Application No: M/91/25/HH

Site Address: 15 Old Point Middleton-On-Sea PO22 7RY

Description of works: Two storey front, rear and side extensions. Loft extension. Internal alterations.

PROPOSED SECOND FLOOR PLAN

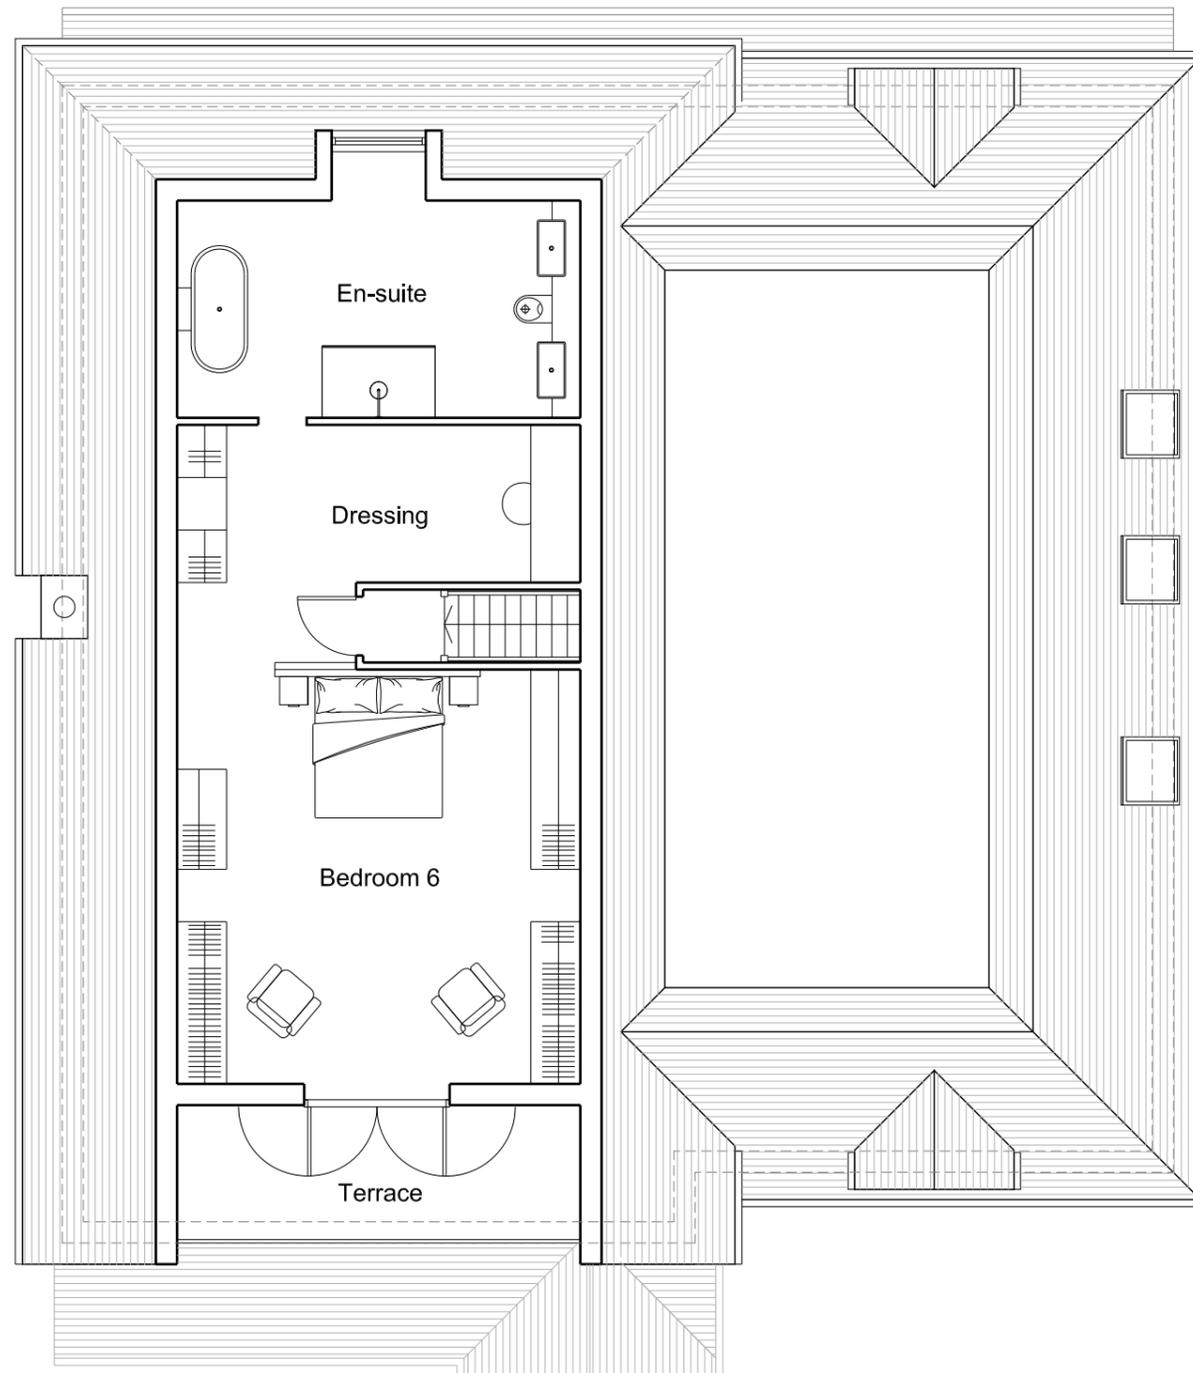
We are concerned about the increase in roof height and volume. In particular, we are very concerned about the additional floor on the south elevation (3 floors overall). The balcony on floor 2 will overlook our bedroom and would therefore be intrusive.
